From: Thomas Callaway
Sent: 08 February 2017 17:06
To: Planning.Responses
Subject: RE: Planning Consultation on: BR/342/16/DOC

APPLICATION NO: **BR/342/16/DOC**

Site Address: University of Chichester Upper Bognor Road Bognor Regis PO21 1HR

Description of Works: Application for approval of matters reserved by conditions imposed under BR/54/16/PL relating to Conditions(s) 10 - Surface water drainage scheme, 16 - Measures to divert public sewers, 17 - Foul & surface water sewerage disposal details & 27 - Details of exact location of the rising main & foul sewer pipe identified & plan identifying Southern Water Infrastructure of locations of the pipe run.

CLIENT:	UNIVERSITY OF CHICHESTER	PROJECT:	UNIVERSITY OF CHICHESTER EDT PARK BOGNOR REGIS
ARCHITECT:	STRIDE TREGLOWN LTD.	TITLE:	PROPOSED DRAINAGE LAYOUT EDT BUILDING

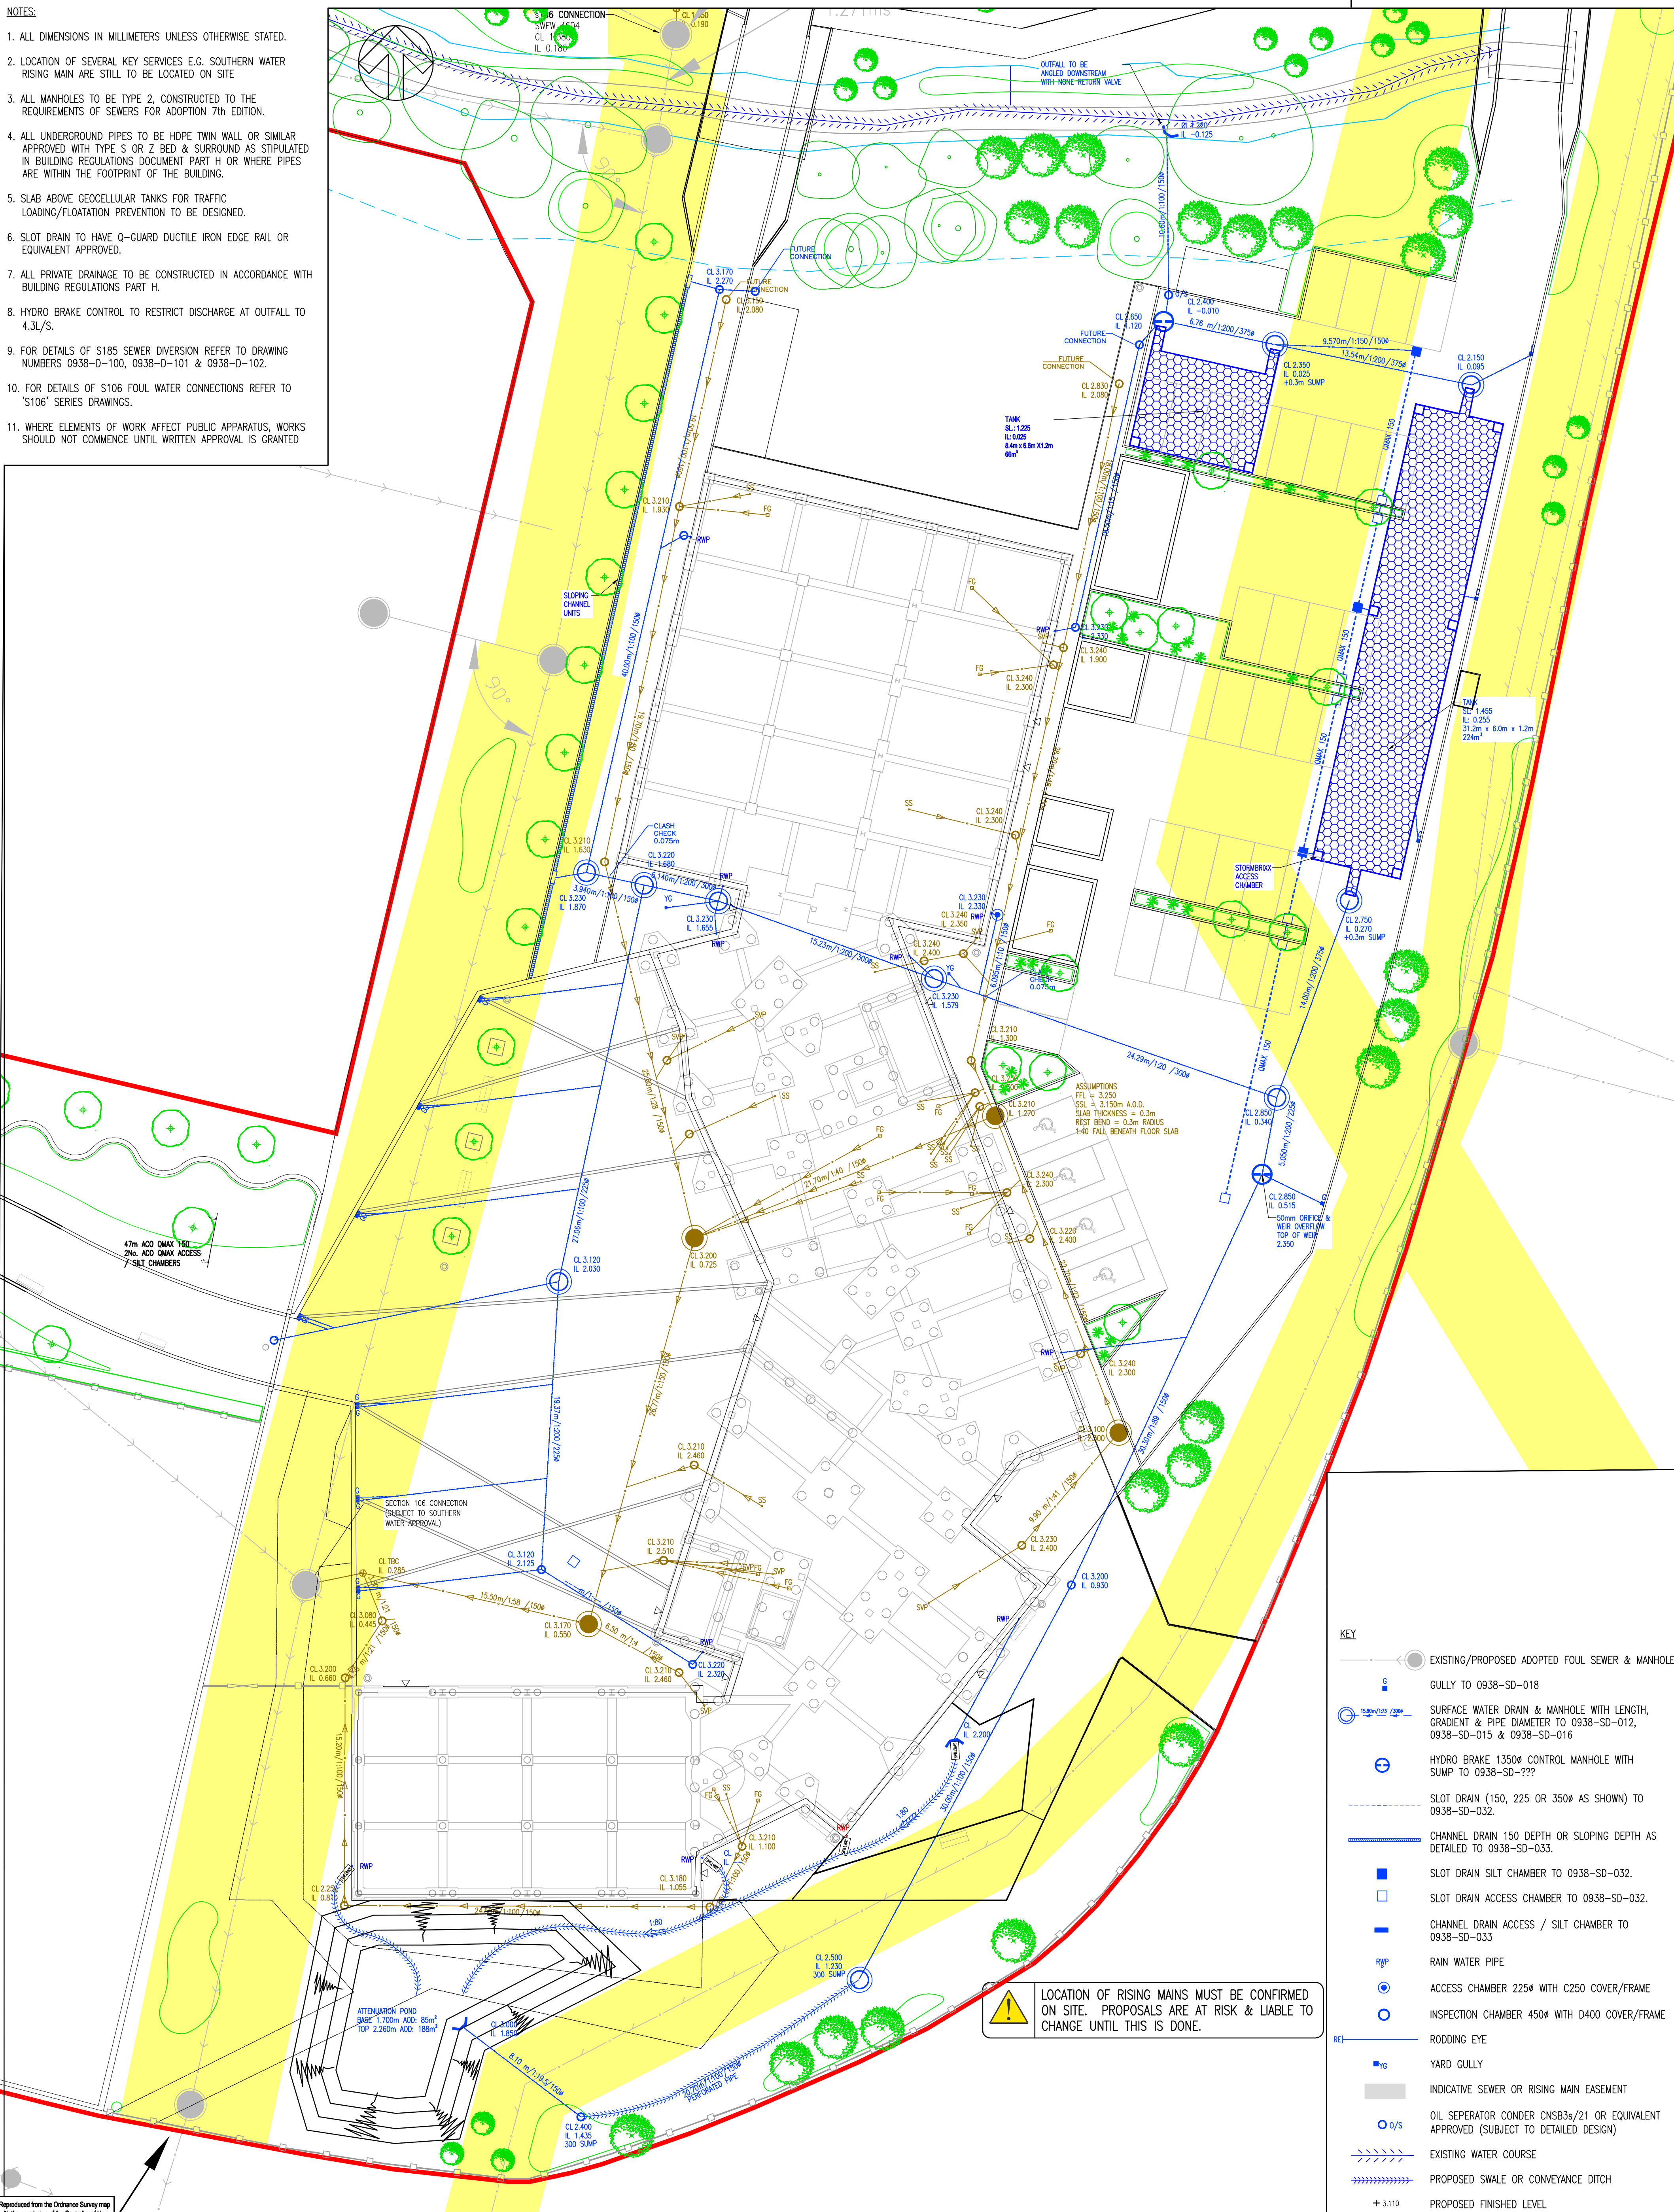
This has been shown as a bold dashed line and it is not clear what this means. It still appears to cross under buildings and potentially clash with surface water drainage for the site, and also with proposed trees. This must be discussed with ourselves and the EA as IDB.

Please provide all necessary calculations showing the storage for the 1 in 100 year storm event plus climate change. There are still warning notices on the plans stating the uncertainties with the sewer locations, please ensure that all details have now been confirmed
